Ref: SSD-81623209- MOD3

**RE: SUBMISSION TO SSD-81623209-MOD3 AT 9-21 BEACONSFIELD PARADE,
LINDFIELD**

Thank you for the opportunity to comment on State Significant Development (SSD) application (SSD81623209-MOD3 for the Design Refinements) at 9-21 Beaconsfield Parade, Lindfield.

Figure 3: Proposed Basement 02

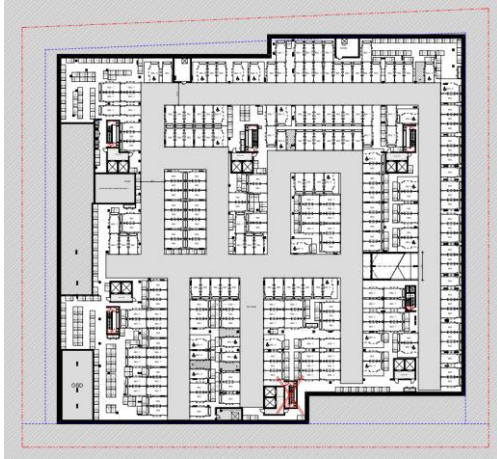
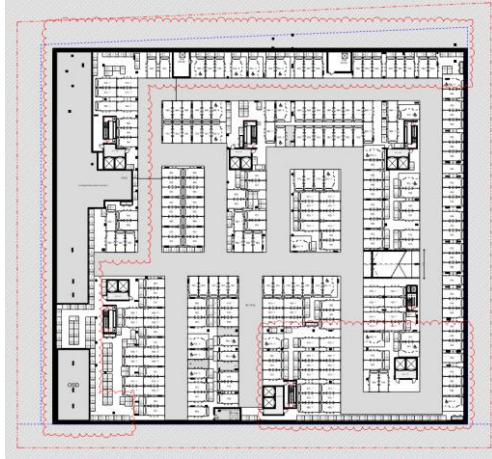
- a) The loading bay as access and space for a MRV and SRV.
- b) The bin holding area is too congested and bins are triple stacked. A collection vehicle for one type of bin will not be able to access all the required bin in this layout.
- c) Bins are stored between two levels of the basement, with a ramp or platform lift. This is considered an inefficient and unacceptable storage solution. All bins and storage areas need to be at loading dock level. The collection crew will not be moving bins between the two levels.

- a) 6 chute rooms are provided across the basement level.
- b) 660L bins are proposed. Council proposes to upsize these to 1100L bins to reduce the number of bins required on site.
- c) It is unclear regarding the proposed chute system. A linear system will be required to automatically move bins under the chute. There needs to be 3 days capacity under the chute. It is unclear the layout of this system as currently show it is incorrect and will not work for most of the chute rooms e.g. A, B, D, E & F

- a) Confirm sufficient access for HRV waste vehicle and safe access for the collection crew.
- b) Confirm loading location for bulky waste. Confirm how the waste will get from the storage room to loading dock. It is not appropriate to be at different levels.
- c) A Loading Dock Management Plan is to be designed and implemented including booking priority access times for residential waste vehicles (**Note:** there will be up to 8 collection vehicles per week for residential waste.)
- d) All carting paths need to be shown on the plan for the manager to move bins from each bin room to the storage room.
- e) A cart and trailer will need to be provided along with a storage space to park the equipment.
- f) A bin lifter will need to be provided.

- a) Ensure there is mechanical bin changing system under each chute.
- b) Amend the chute rooms to allow linneras to automatically move bins along. Note: there needs to be space on either side the chute for bins to move under it.
- c) Provide carting path maps from the chute rooms to the bin storage room.
- d) Remove separate FO bin rooms.
